10 Island Street

I thank you all for responding to the emails from concerned neighbors of the 10 Island Street building proposal. There are still questions that have not been answered.

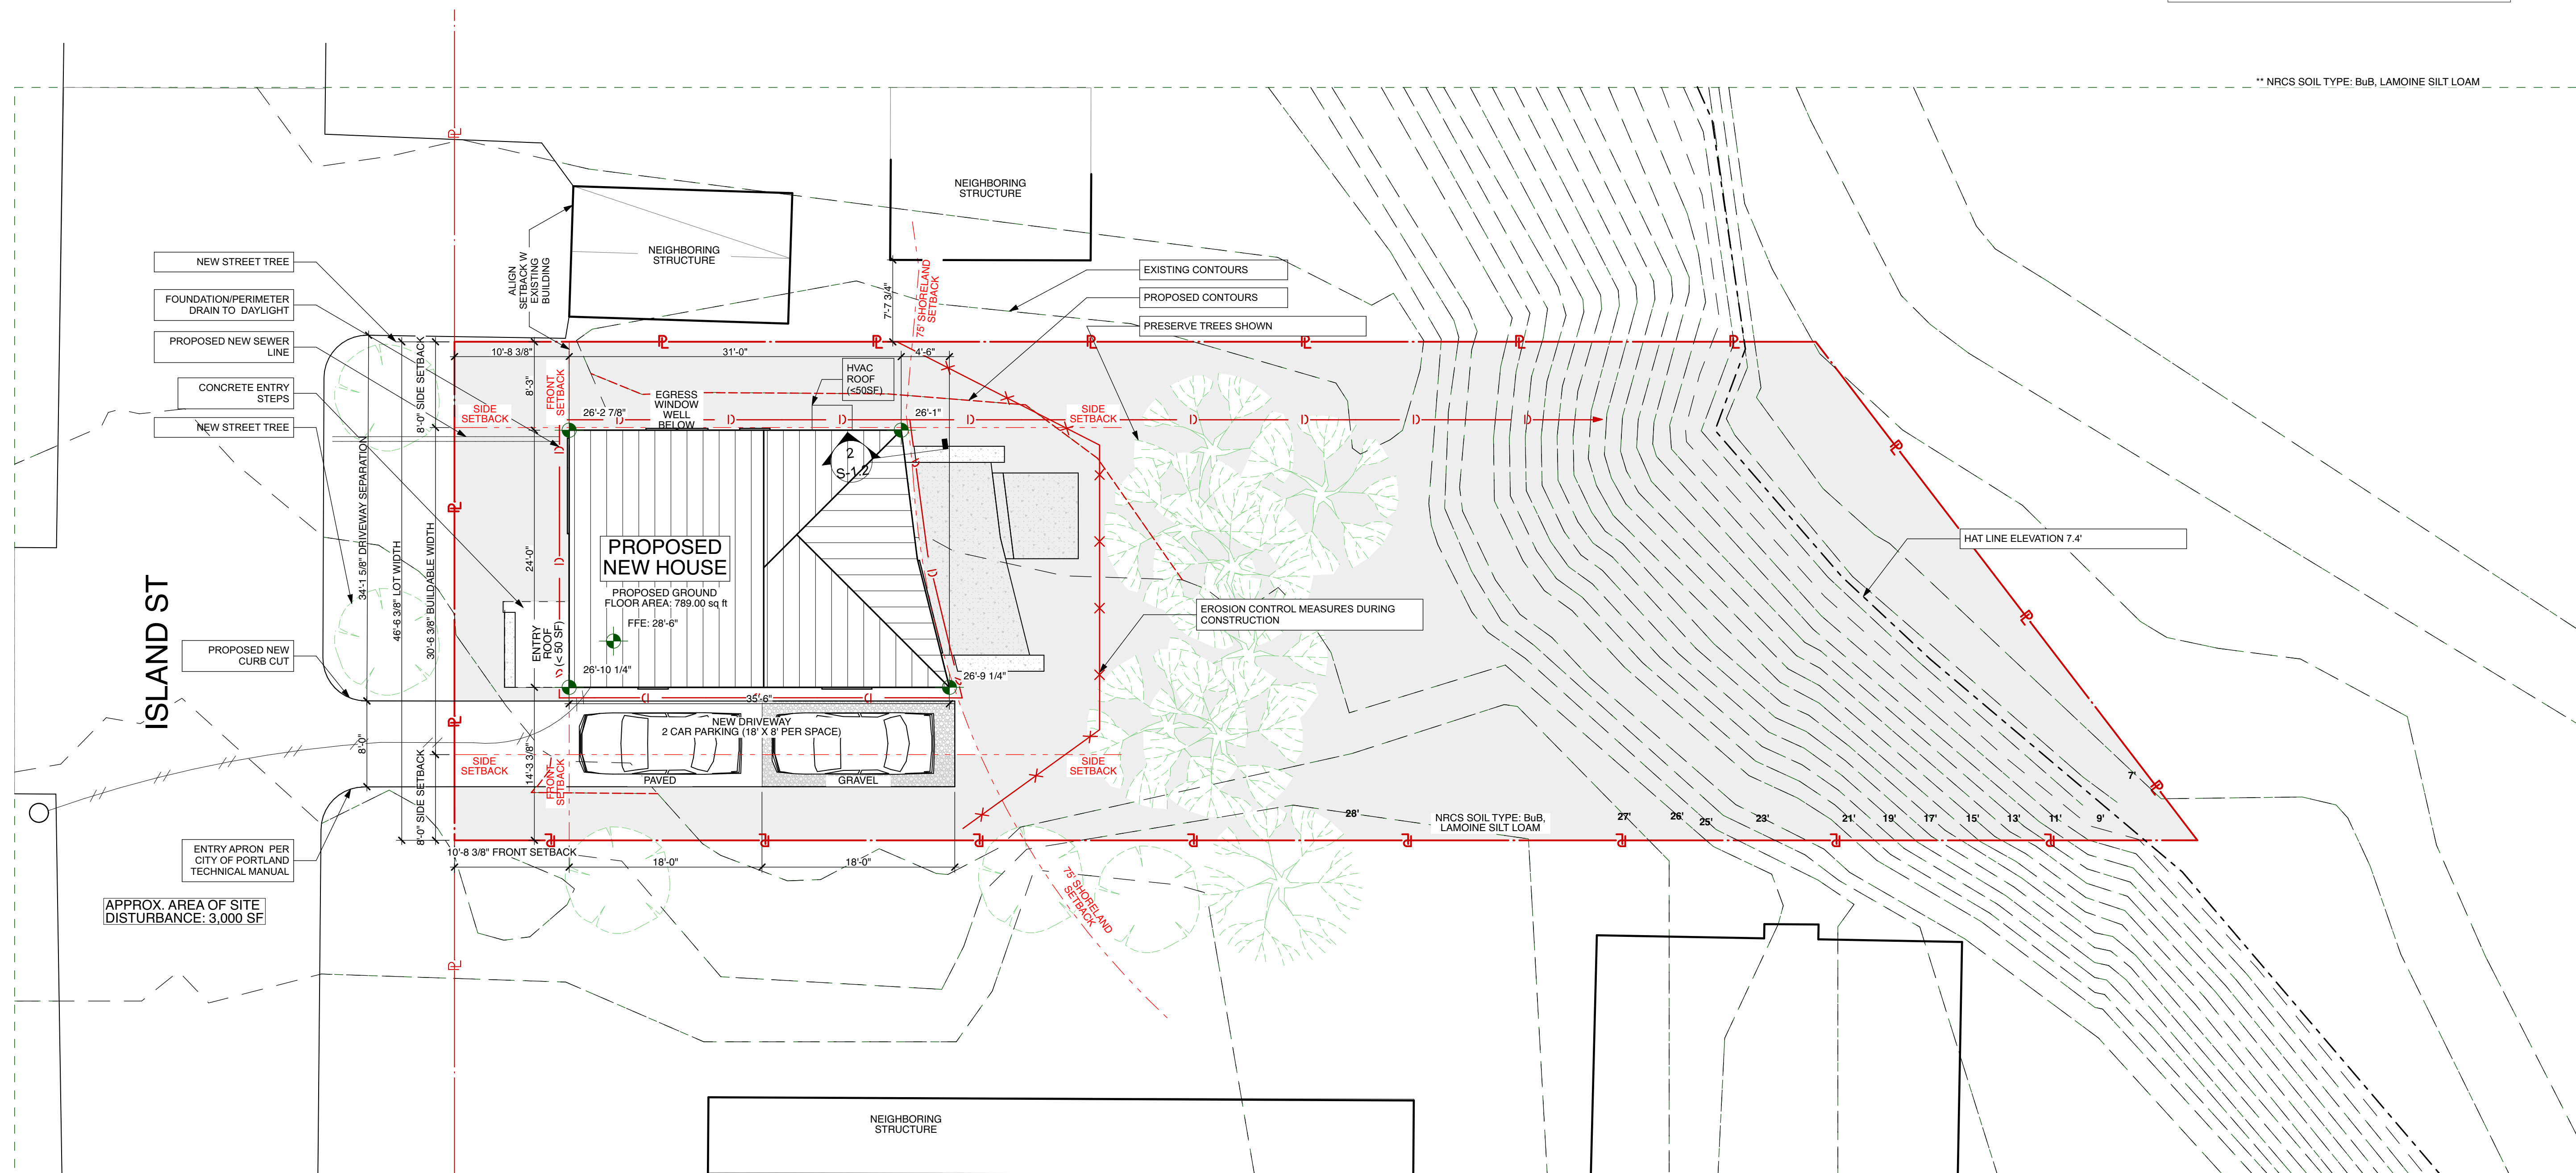
One of which is that the site plan does not accurately depict the 75 foot setback. This was done from a 2015 HAT line. It needs to be remeasured using the 2017 HAT which is higher than in 2015. The trend for the last 10 years shows the rising HAT line. This should be a huge consideration.

Also the plans do not adhere to the full setback from the front of the street. The front setback should be greater than is shown on the plan.

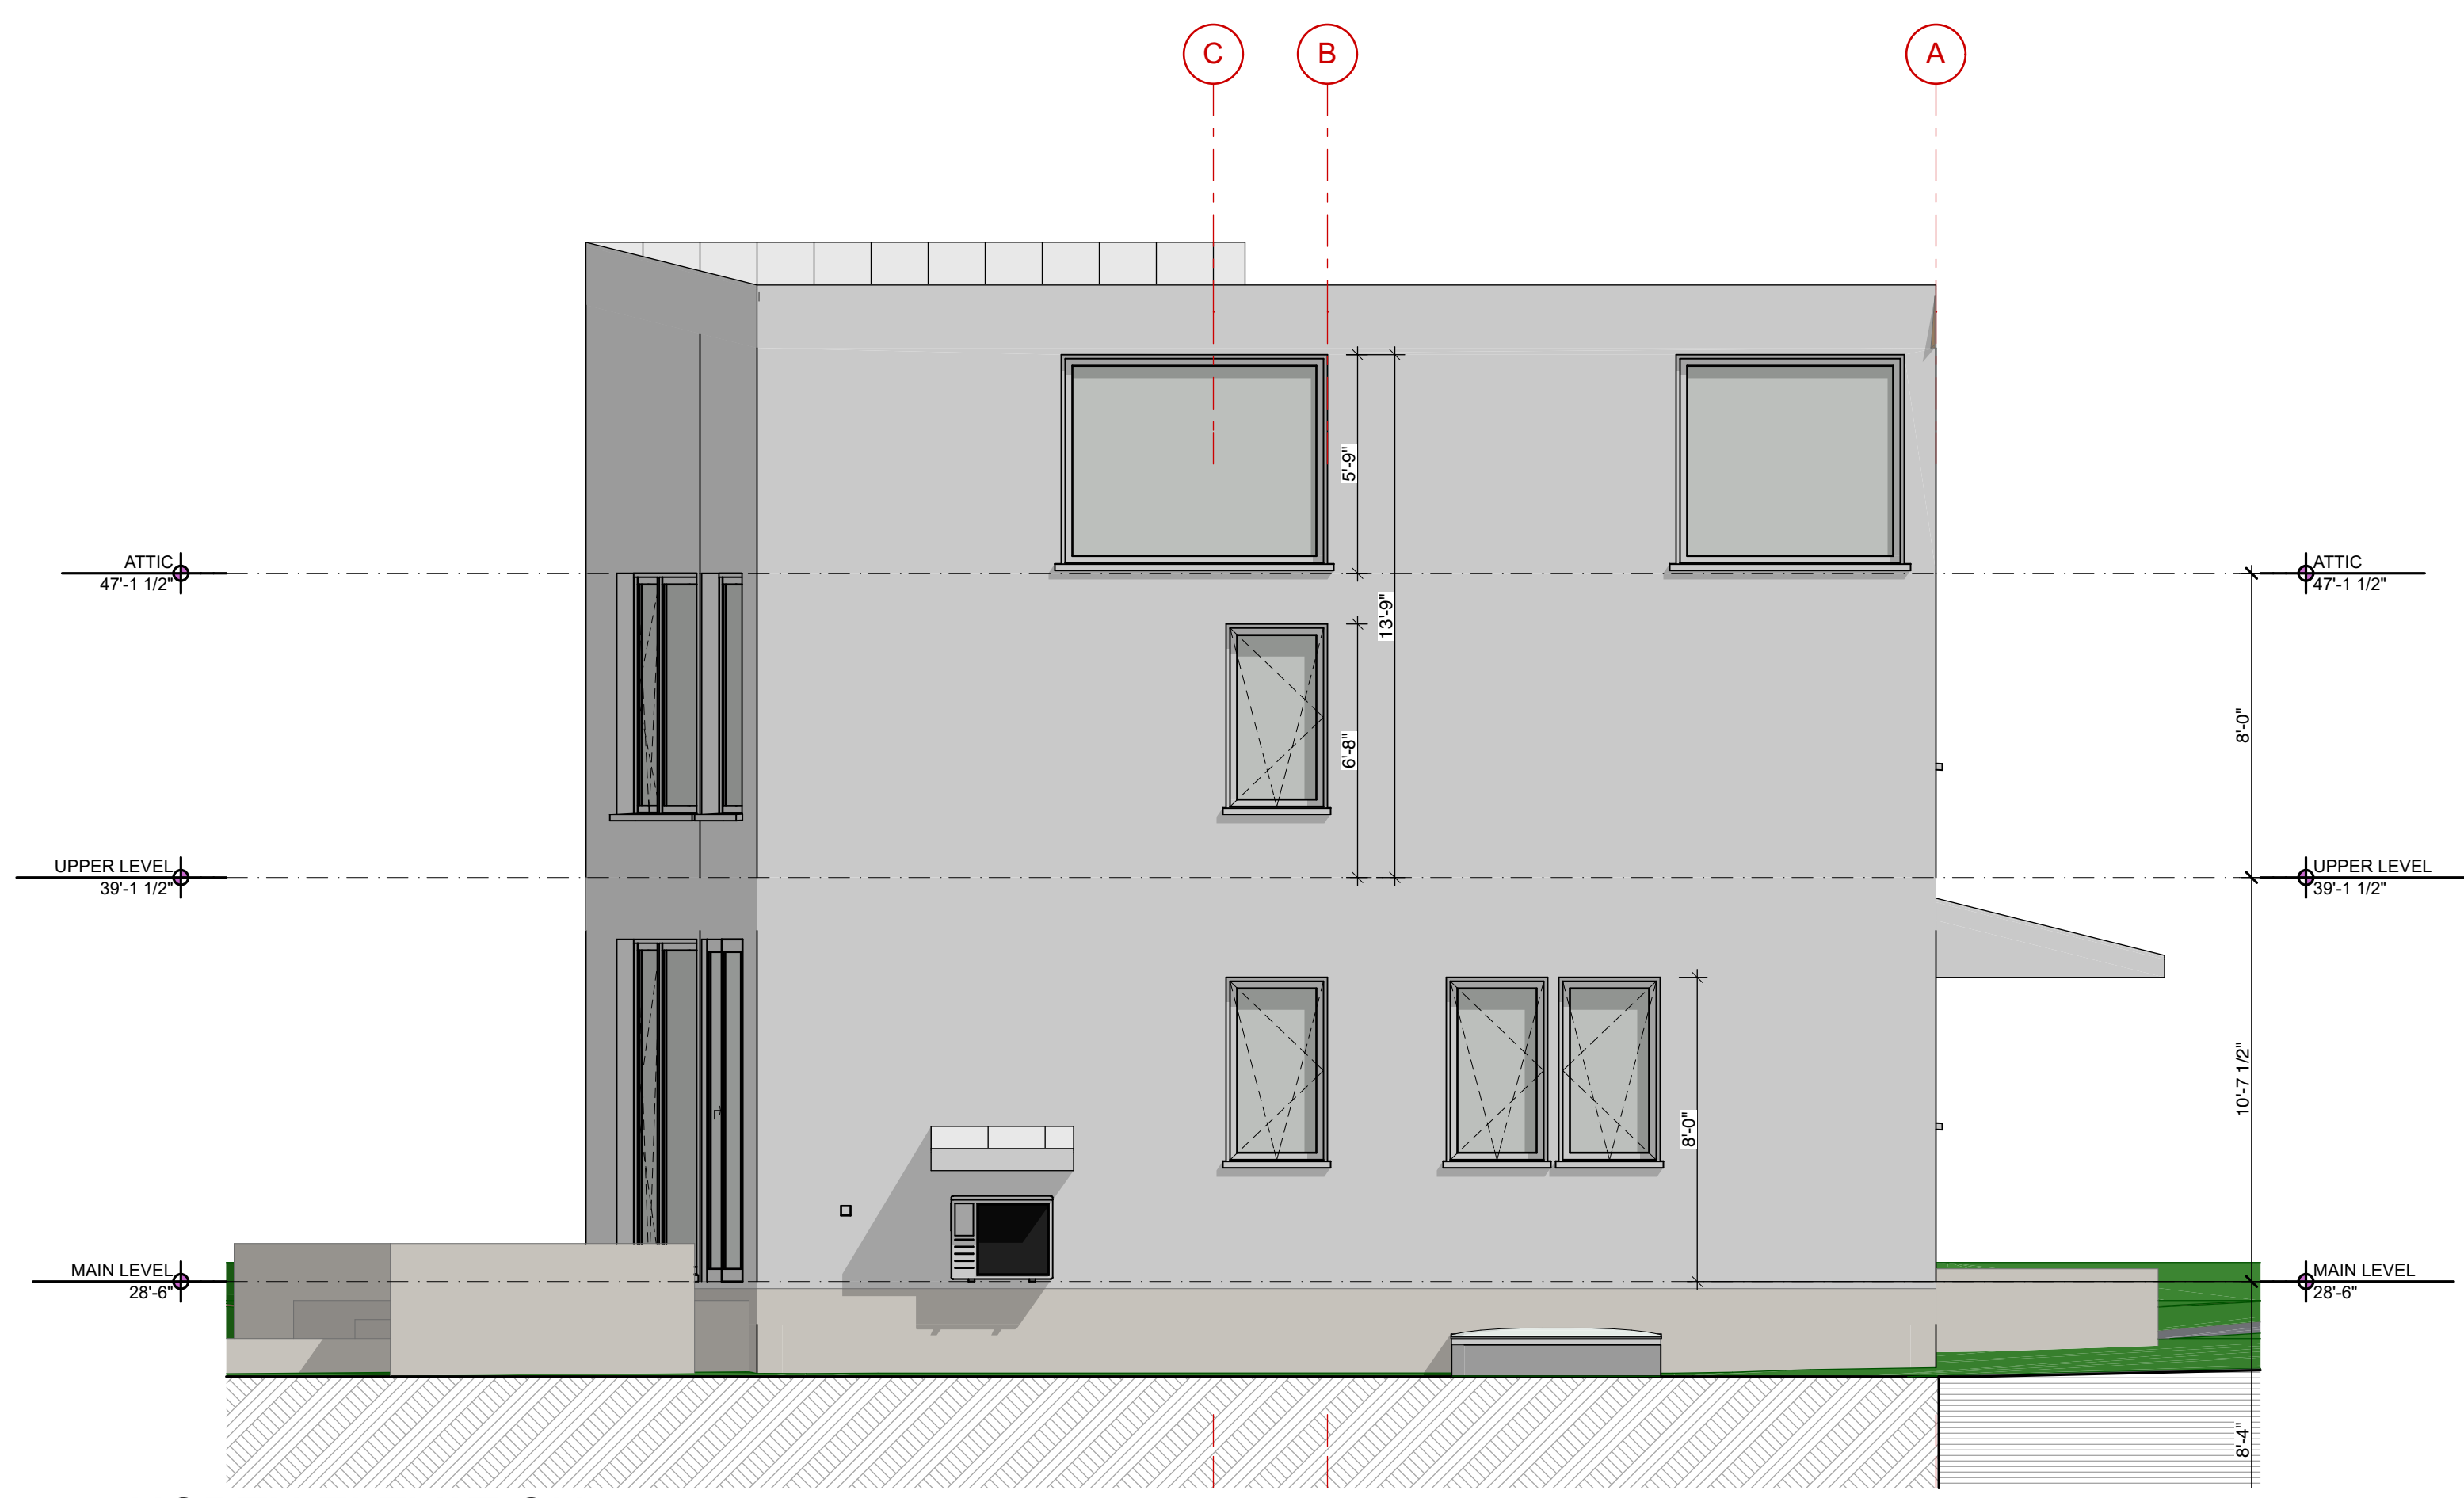
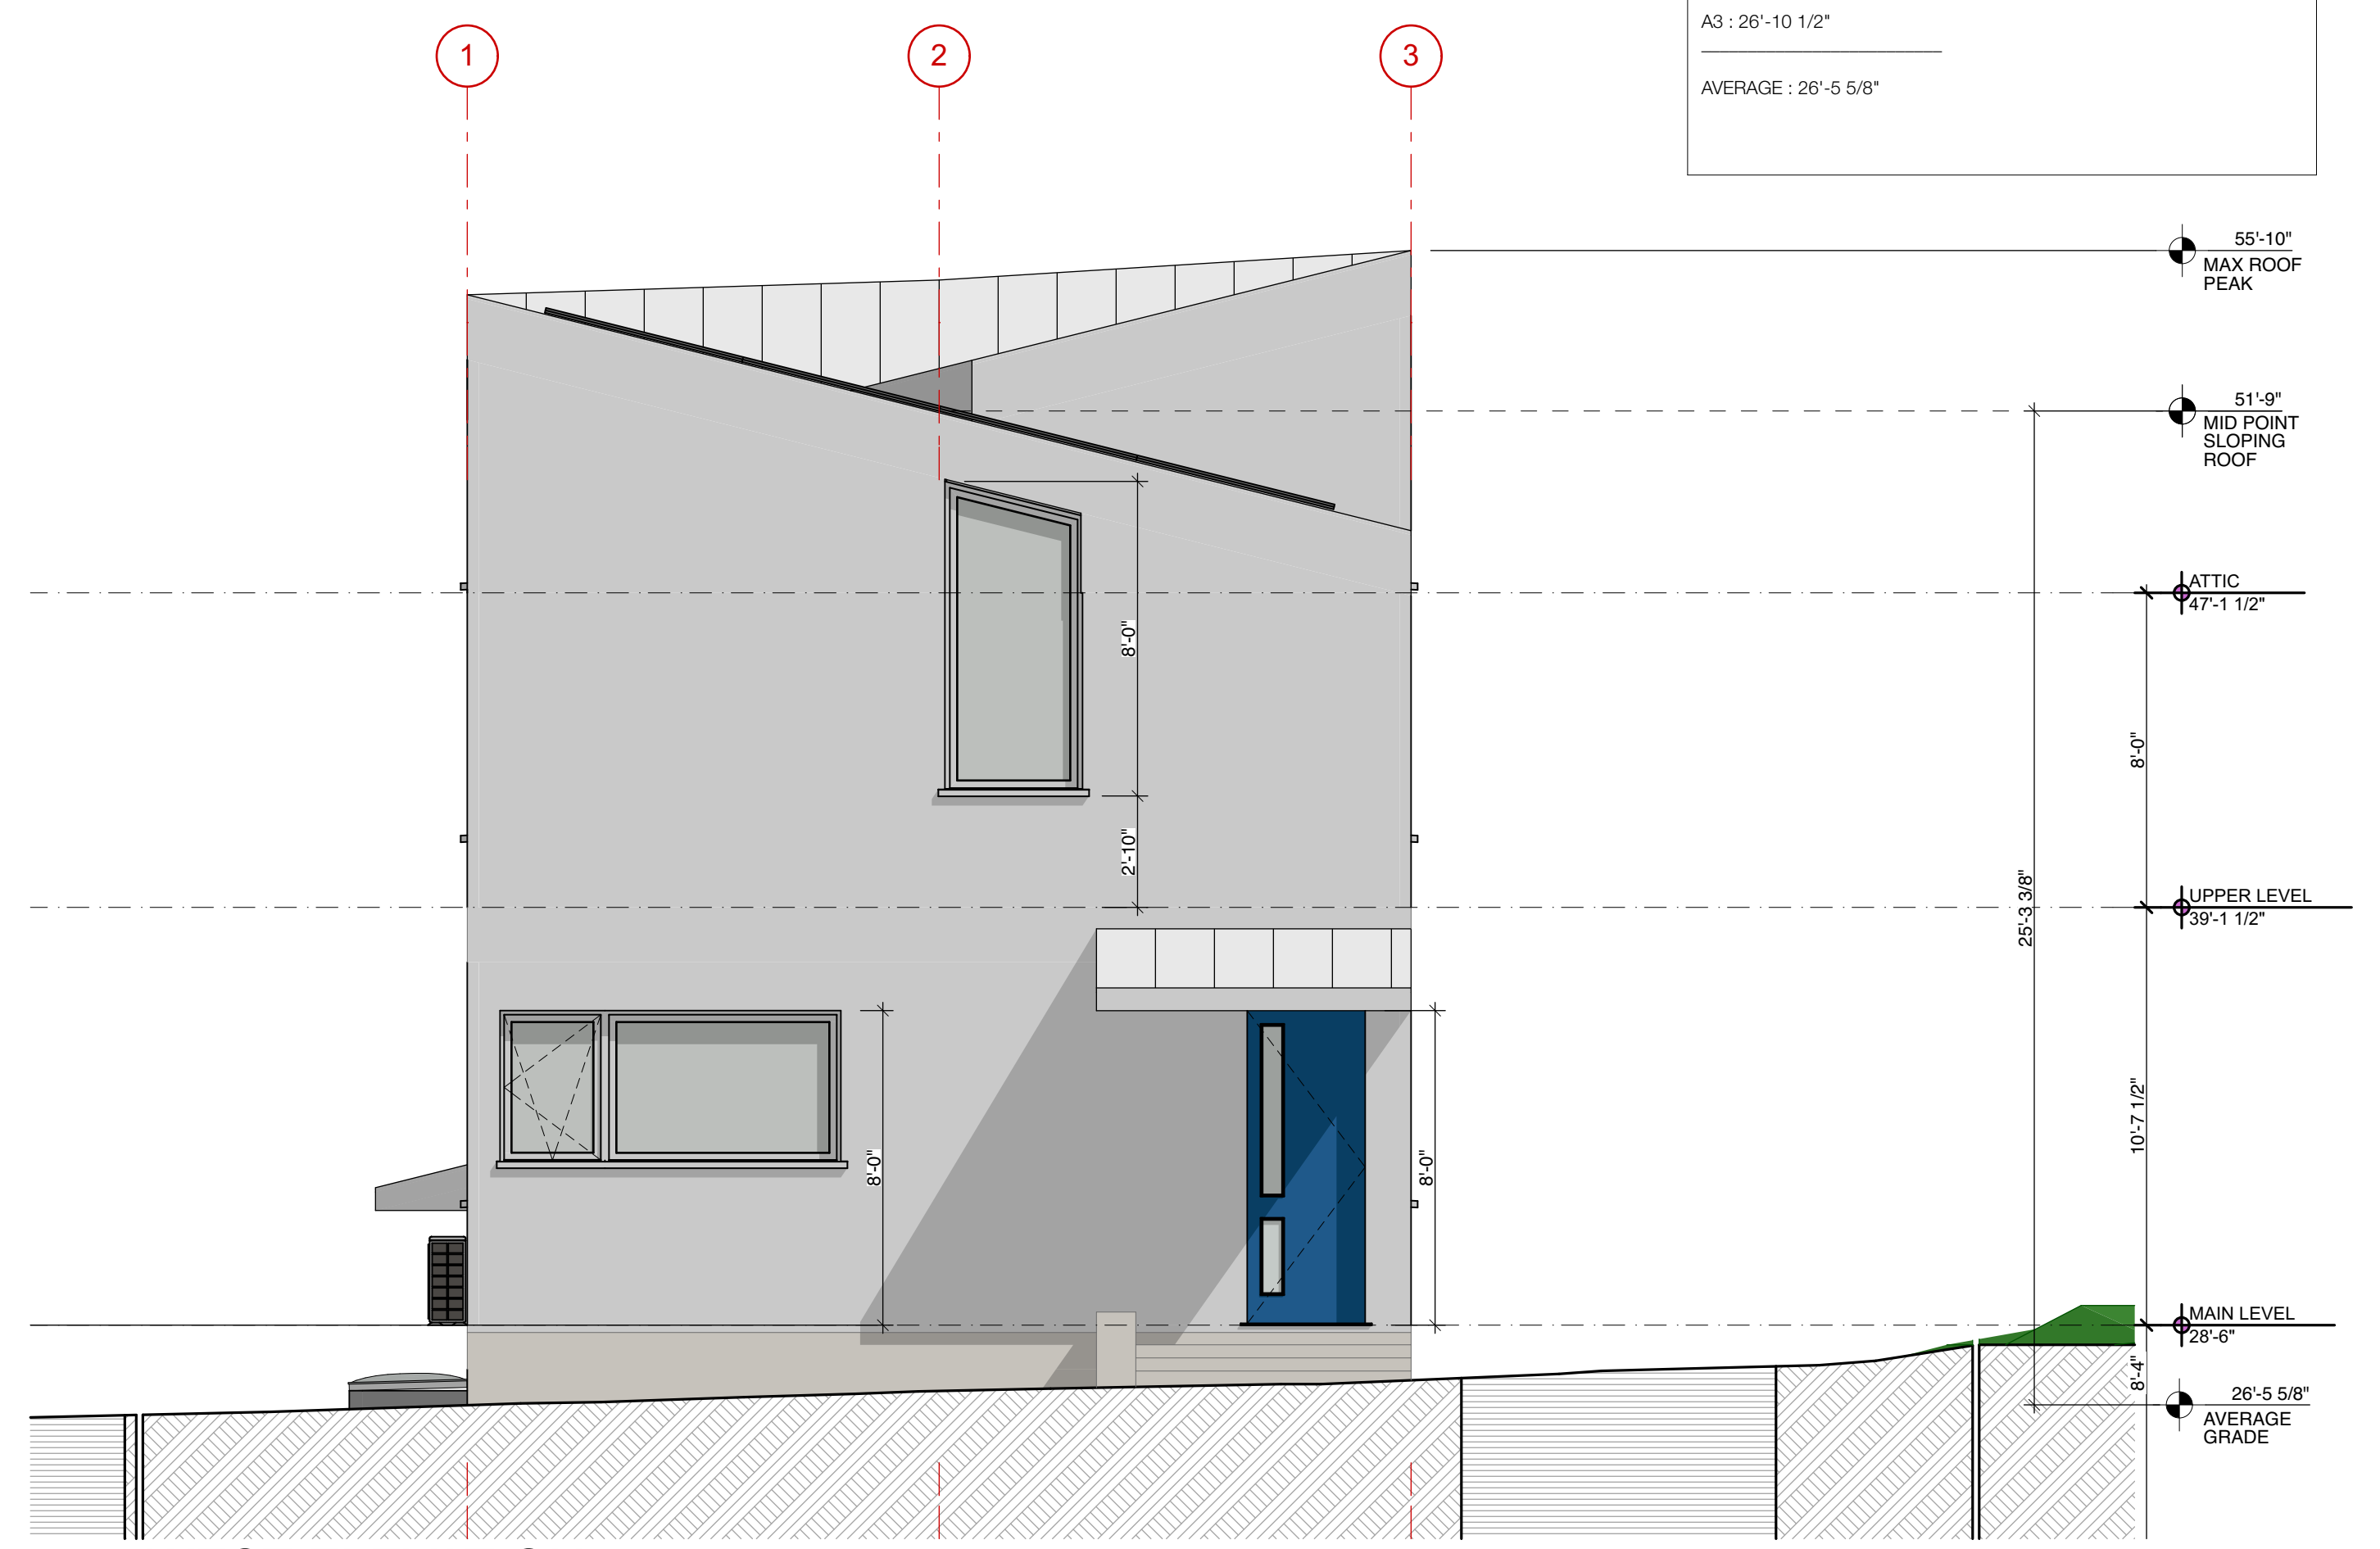
Another issue is simply that this proposed structure does just not fit in any way with the aesthetic of our little coastal neighborhood. We are a small residential community in Portland but tucked away between the sea and Interstate 295. Most of the houses are quaint clapboard and have been around for awhile. This obtrusive modern structure just does not fit here.
